8755 NC. 42

COMMERCIAL
BUILDING REVIEW

KIDD'S PLACE SHELTER

KIDD'S PLACE SHELTER

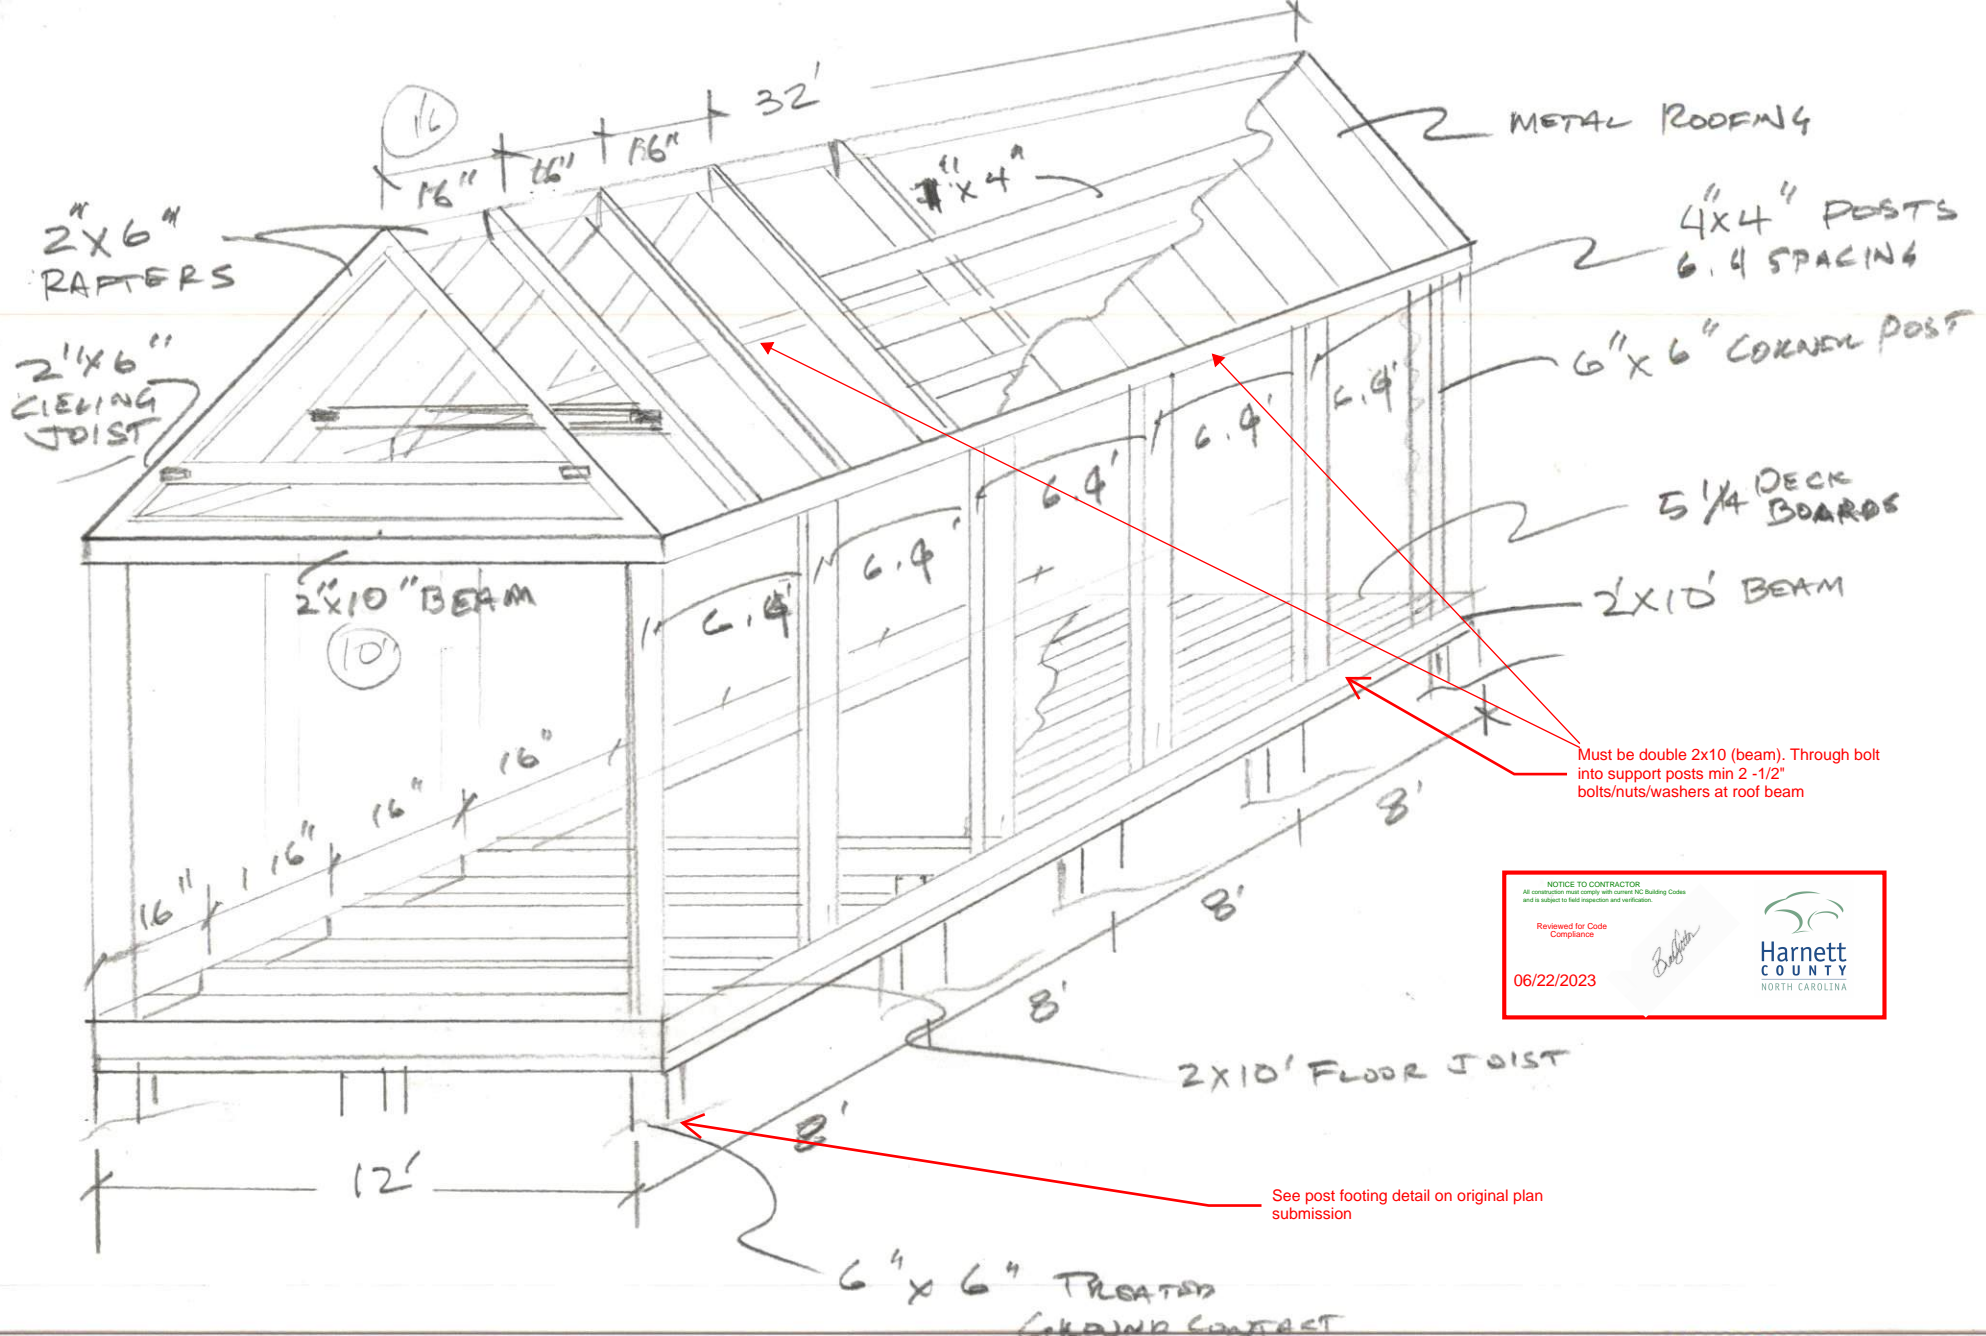
- ✓ 1. Need post spacing shown for deck and roof.
- ✓ 2. Need beam size shown for deck and roof.
- ✓ 3. Need floor joist size and spacing for deck and decking type
- ✓ 4. Roof must have ceiling joists in lower 1/3 of rafter span, or engineered trusses must be used. If using trusses, supply layout for truss supplier.
